CITY OF PORTLAND

BUILDING PERMIT

Located At 62 WESTMINSTER AVE

Job No: 2011-10-2356-ALTR 2012-14371-amend	Date Applied: 12/28/2011	CBL: 181- A-005-001	
Location of Construction: 62 WESTMINSTER AVE	Owner Name: THOMAS & KAREN PARADIS	Owner Address: 62 WESTMINSTER AVE PORTLAND,ME 04103	Phone: 207-318-5986
Business Name:	Contractor Name: Owner	Contractor Address:	Phone:
Lessee/Buyer's Name:	Phone:	Permit Type: BLDG - Building	Zone: R-3
Past Use: Single family with home occupation	Proposed Use: Same – single family with home occupation – amend permit 2011-10-2356 – change from two story 17' x 35' addition to a one story 17' x 35' addition	Cost of Work: 1000.00	CEO District:
		Fire Dept: <input checked="" type="checkbox"/> Approved w/condition <input type="checkbox"/> Denied <input type="checkbox"/> N/A Signature: <i>Capt. Perrine 1/16/12</i>	Inspection: Use Group: R3 Type: SB MUBEC Signature: <i>[Signature]</i>
Proposed Project Description: amend 2011-10-2356 –change addition on rear to one story		Pedestrian Activities District (P.A.D.)

ADDITION TO:
PARADIS RESIDENCE
62 WESTMINSTER STREET
PORTLAND, ME. 04101
SECOND FLOOR FRAMING PLAN

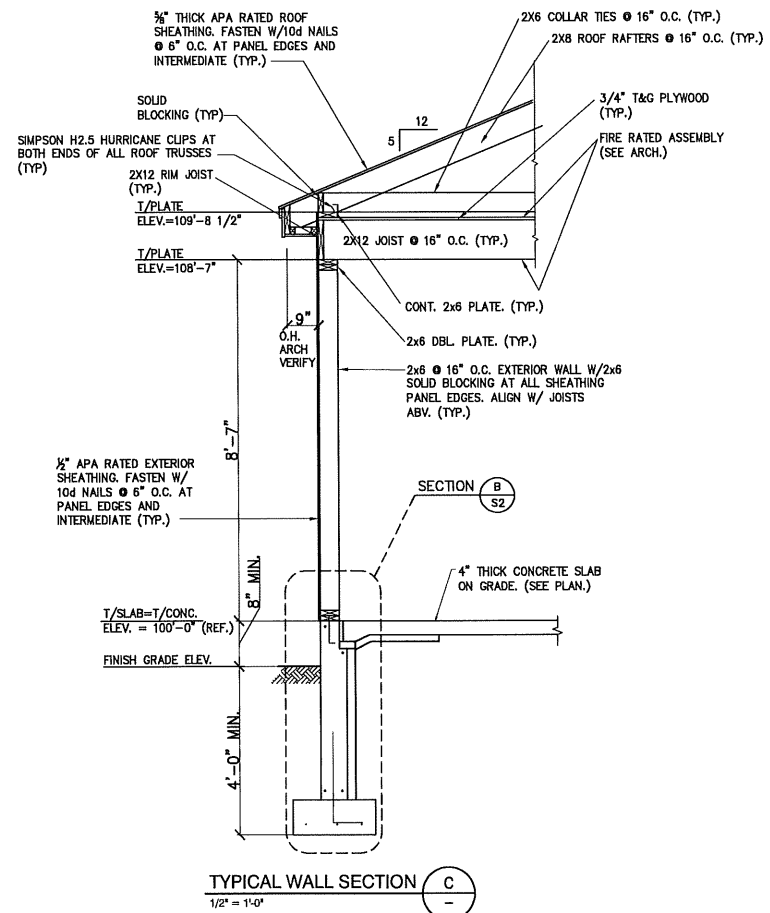
The header in the schedule (8'-7" to 10'-6" maximum rough opening) is designed for the future expansion (two stories) which includes the weight of the second floor as well as the roof on the header above the bay window. The header required for the two story application is a 5 1/4" x 11 7/8" LVL as stated in the schedule with 3-2x6 jack studs. However, with the single story condition with roof load only on the header (plus the additional dead weight of the second floor joists that are installed) and the rough opening only 9'-0" (please verify) the header is more lightly loaded and only requires a single 2x6 jack stud (marginal).

I assume the appropriate 5 1/4" x 11 7/8" LVL header was installed above the opening. Hence, when the future expansion is implemented (i.e. two stories), the single jack stud will be inadequate to support the intended load. To remedy this issue during the proposed future expansion, an additional header will have to be installed in the second floor wall directly above the first floor header to remove the weight of the roof from the first floor header and the jack studs for the second floor header will have to align with the king studs at both ends of the header on the first floor. This does not mean that a window will have to be installed, only that the second floor wall shall be framed in this manner.

There are concealed flange beam hangers that could have been installed prior to the header installation. Yet that is not a good solution now as it would require the removal of the header to install. In addition, there are "header hangers" that could be installed now without removing the header yet they do not have nearly the capacity required.
